WEST SUSSEX COUNTY COUNCIL CONSULTATION

TO:	Arun District Council FAO: Michael Eastham
FROM:	Stephen Gee WSCC - Highways Authority
DATE:	17 May 2019
LOCATION:	Boweries Barnham Road Chichester PO20 3RT
SUBJECT:	EG/22/19/OUT Outline application with some matters reserved for the erection of 28 No. dwellings, access, landscaping & associated works (resubmission following EG/42/18/OUT).
DATE OF SITE VISIT:	3/8/18
RECOMMENDATION:	No Objection
S106 CONTRIBUTION TOTAL:	£ See below for breakdown.

FIGURE 1.4

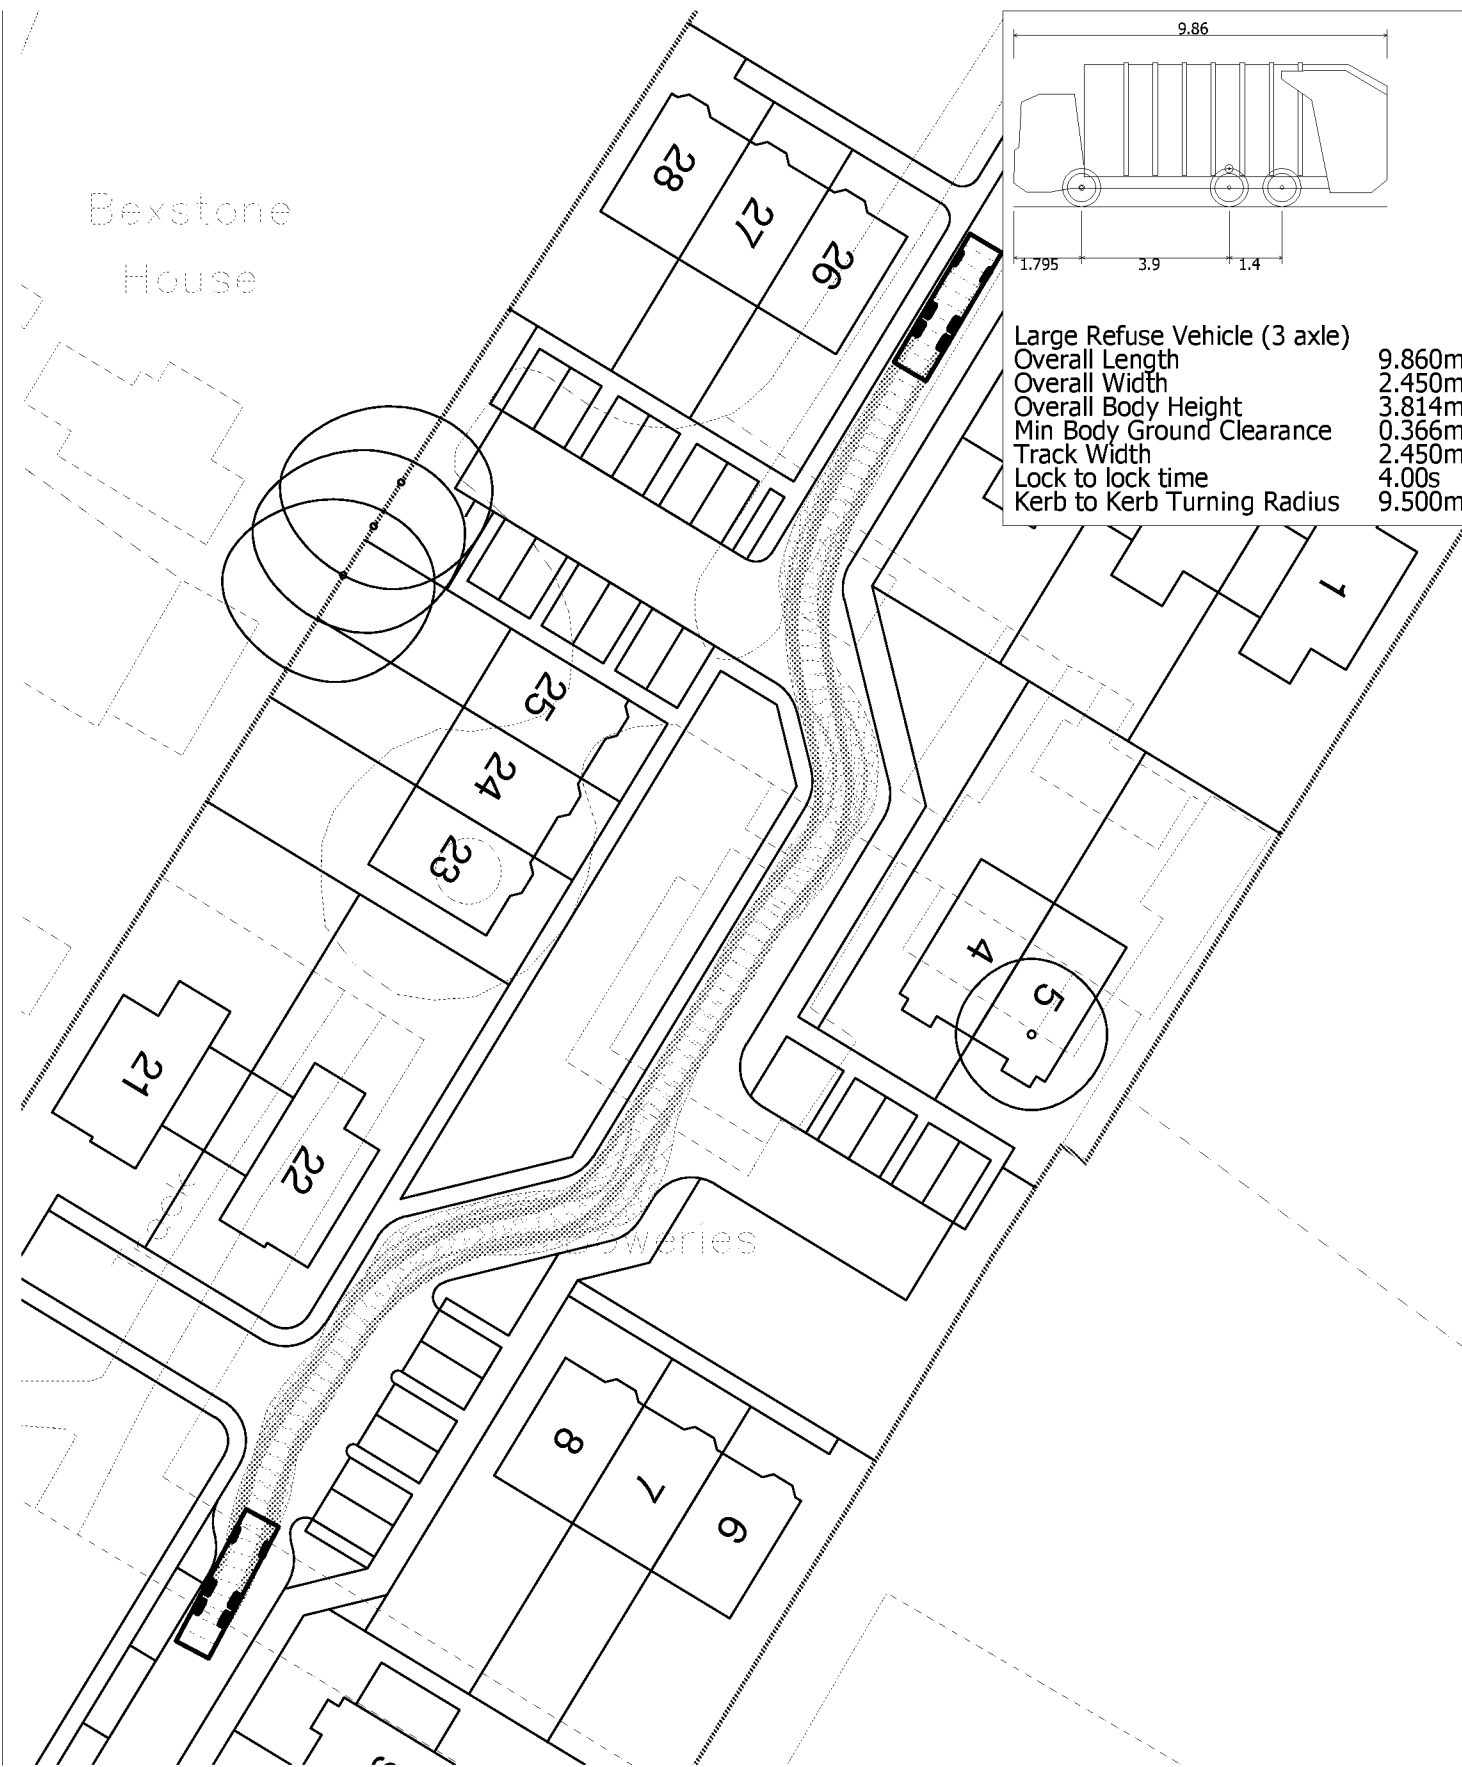
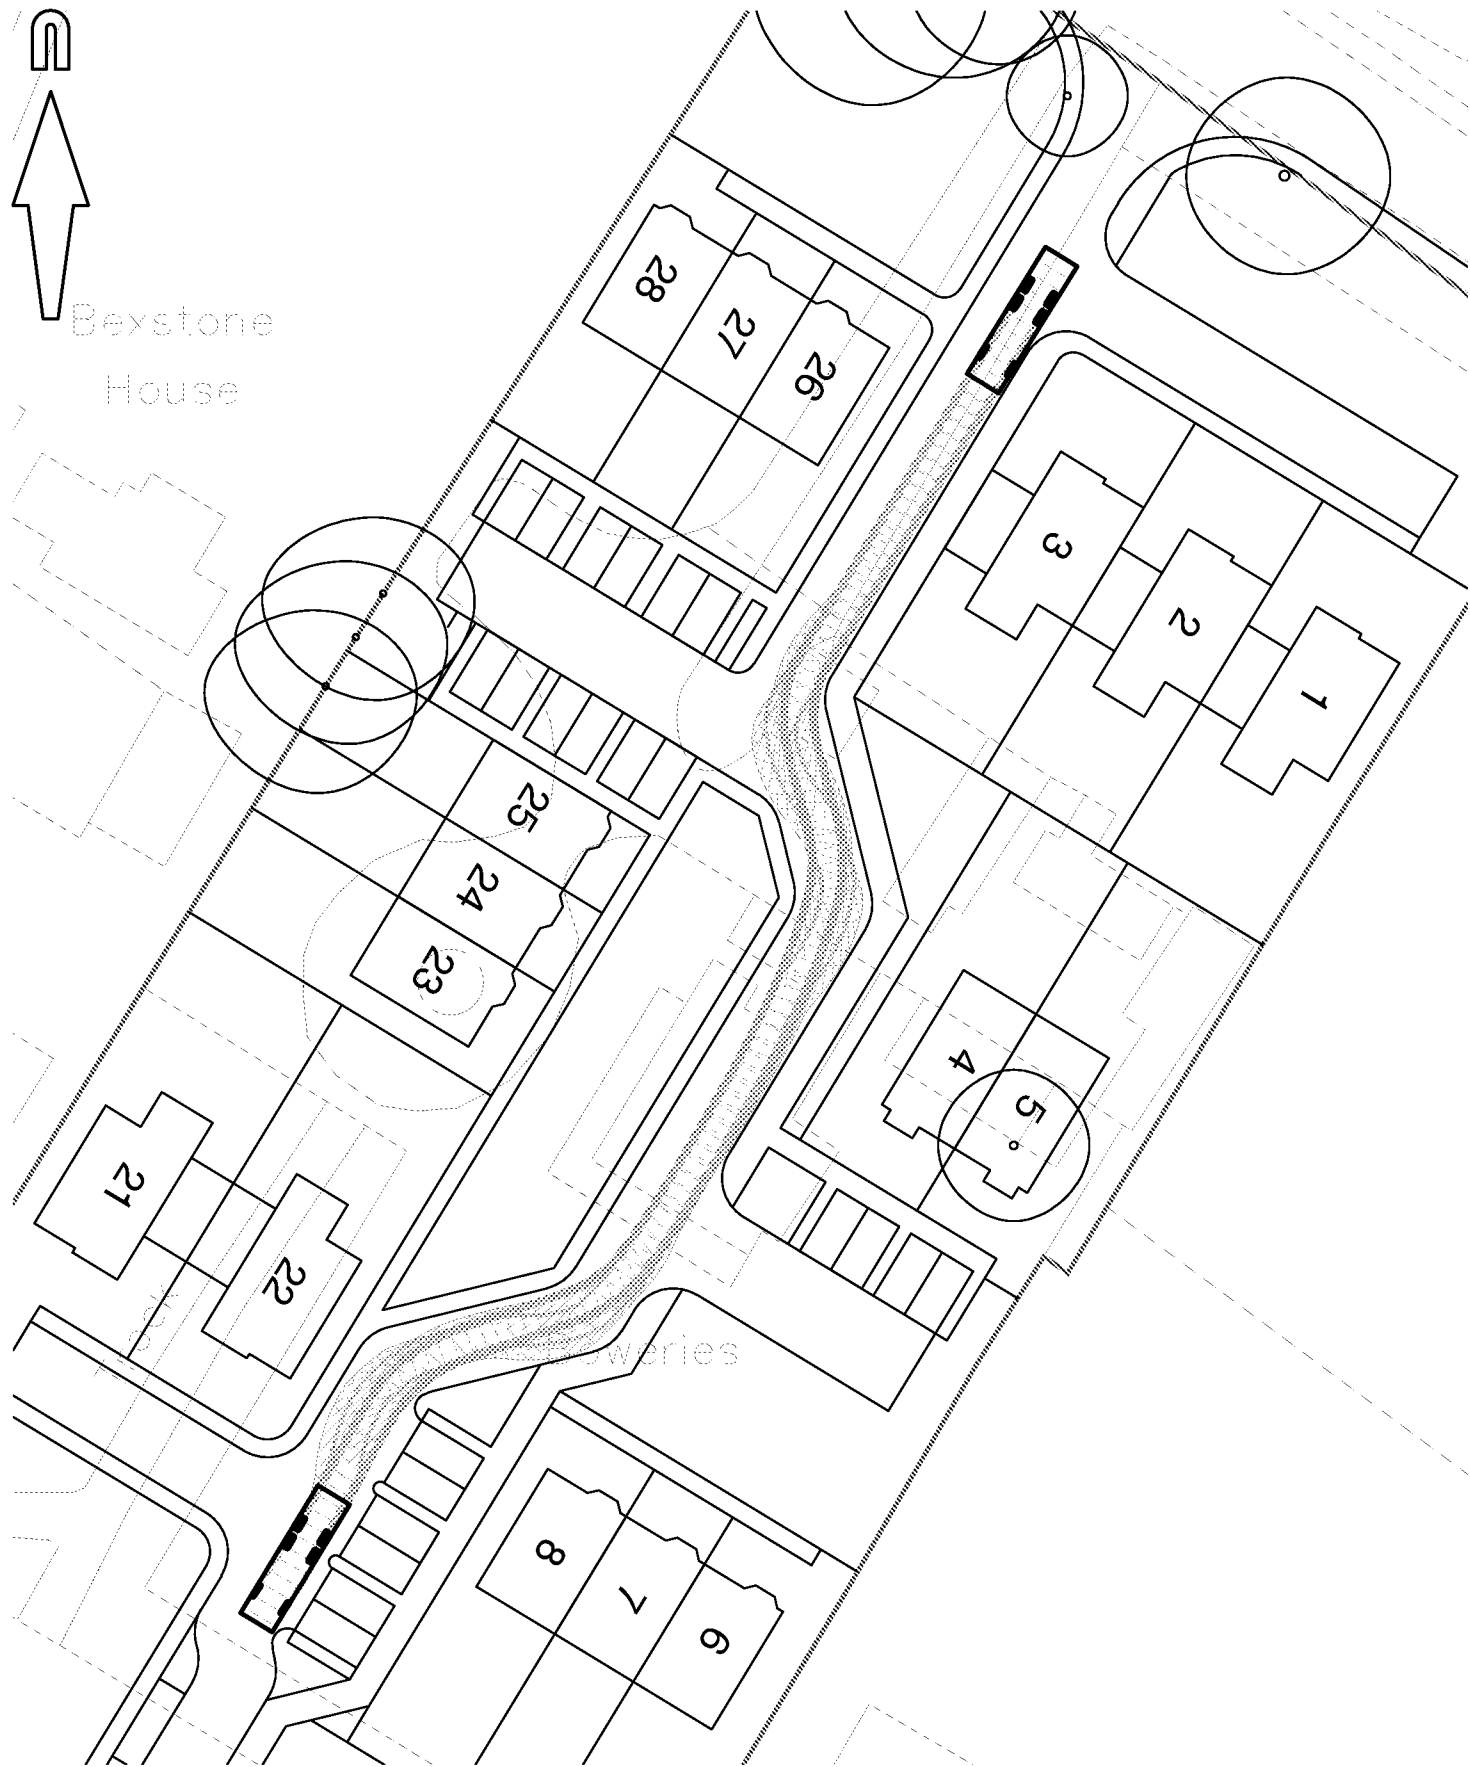
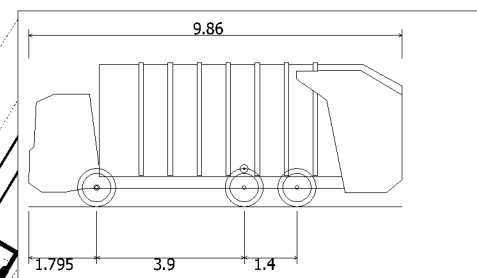
Additional vehicle tracking has been provided and is accepted.

client			
Domusea Limited			
project			
The Boweries Barnham Road Eastergate			
title			
Wider Development and Landscape Framework Plan			
date	scale @ A3	drawn	chkd
Jan 2019	1:1500	MRL	GBC
project no.	drawing no.	rev	
1815	1000	P01

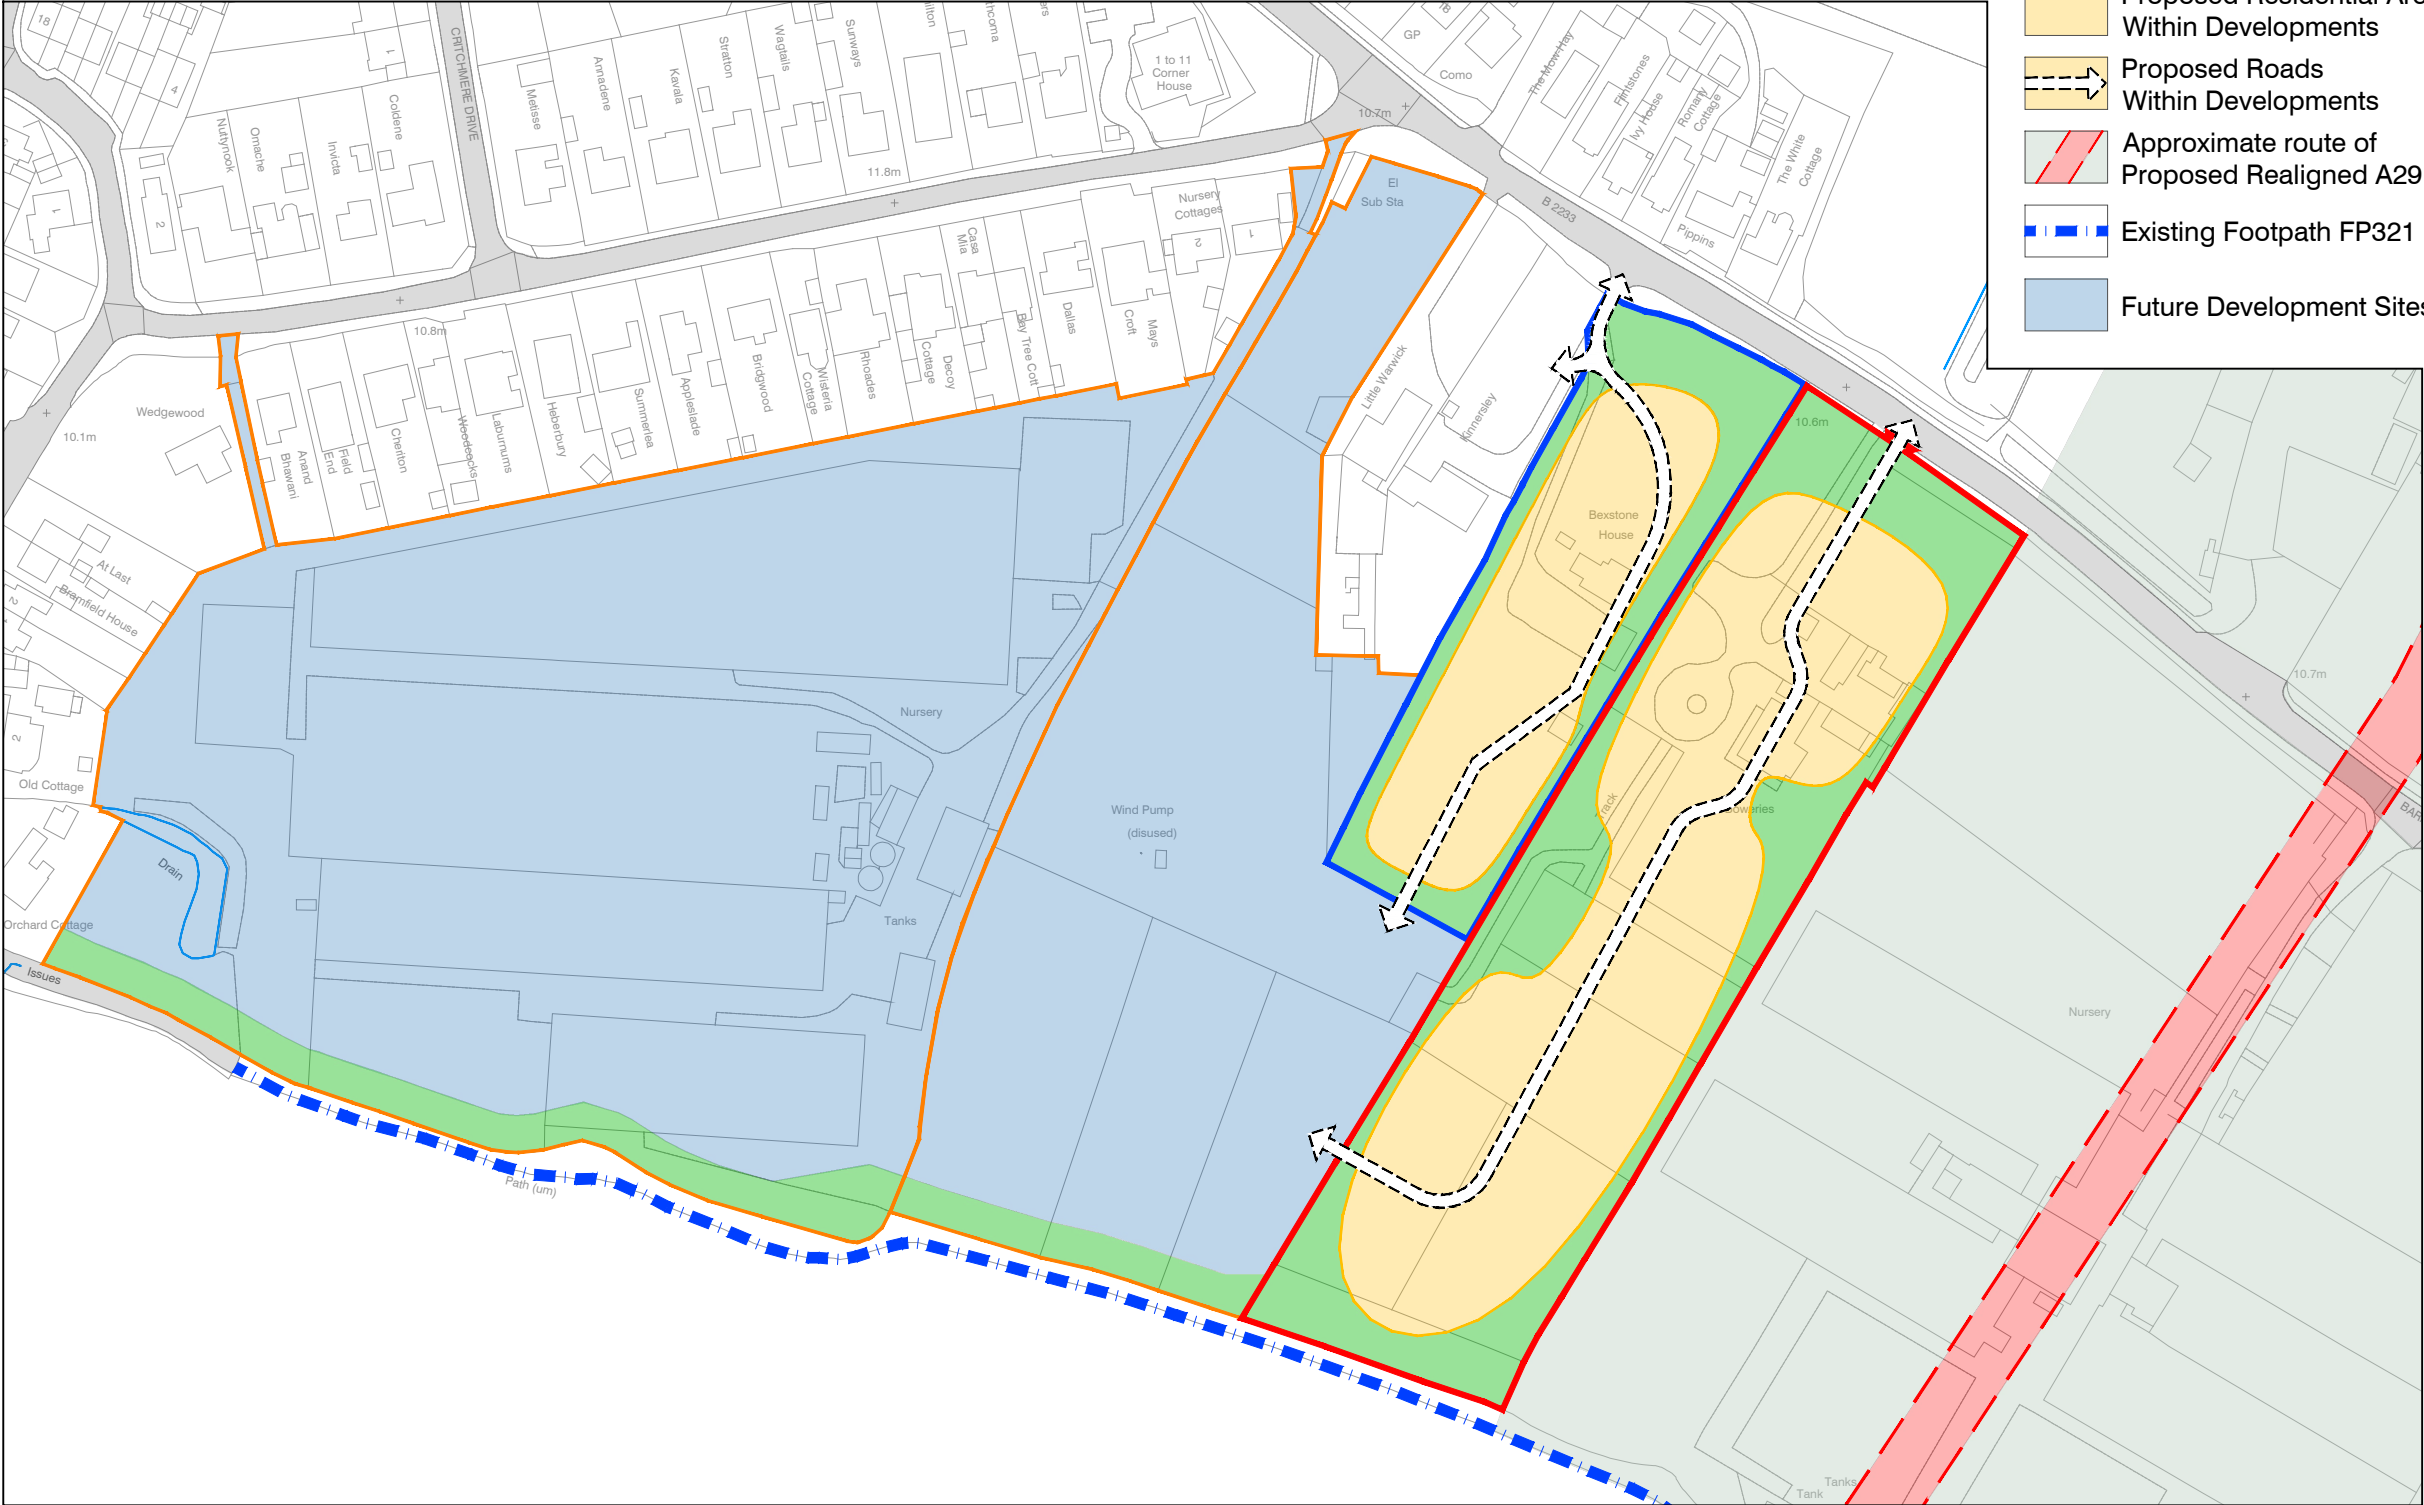
The revised proposed site layout plan shows a connection into neighbouring land via the southern turning head. A turning head/drive is also located close to the boundary of Bexstone House (also included within the strategic allocation and could provide future linkages).

Public Footpath 321 runs along the southern boundary of the site. The strategic landscape masterplan highlights a pedestrian link from the footpath into the development. The footpath is identified as a future cycle link within the WSCC walking and cycling strategy and as such the link into the development should be incorporated as and when layout is considered.
